From: Laura Gibbons
Sent: 26 April 2018 13:26
To: Planning.Responses
Subject: RE: Planning Consultation on: BE/38/18/RES

Engineers comments relating to drainage:

APPLICATION BE/38/18/RES

Description of Works: Approval of reserved matters following outline consent BE/138/16/OUT for 2 No. dwellings

Client
Matt Lush
Drawing Title
Drainage Layout

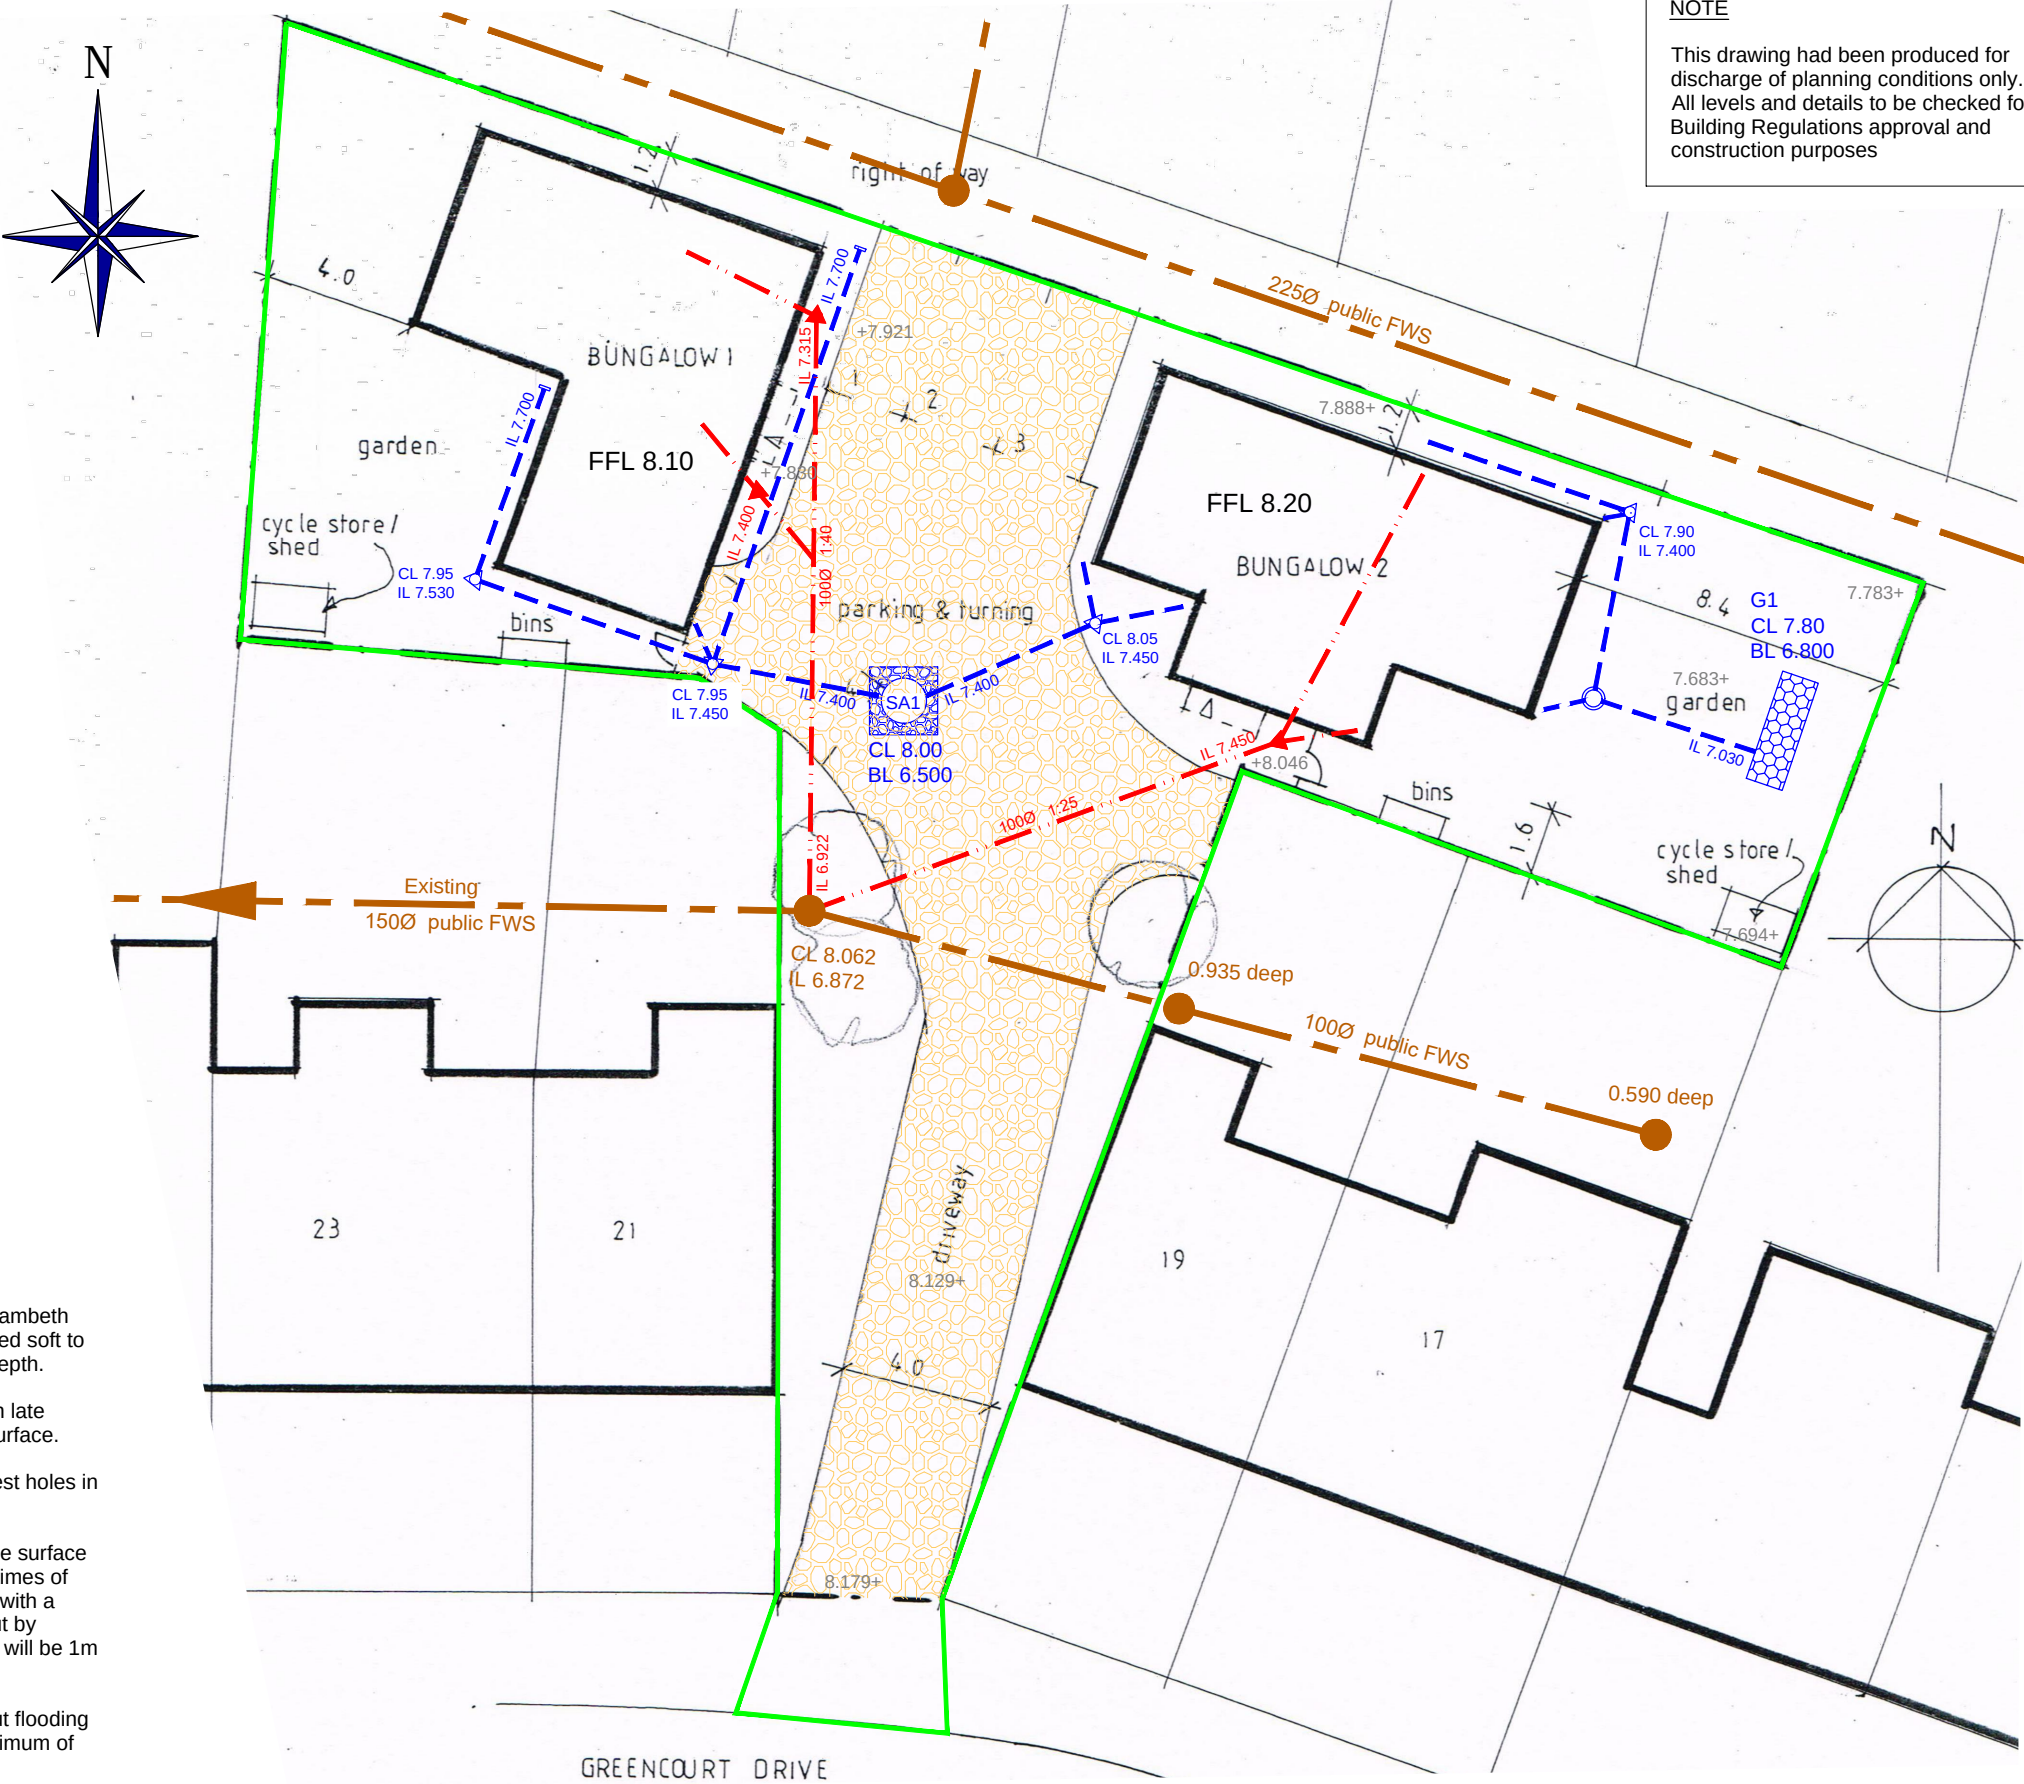
I have reviewed the drainage design provided and note that the soakaway depth is 400mm, the maximum calculated water depth exceeds this, please revise before submitting DOC.
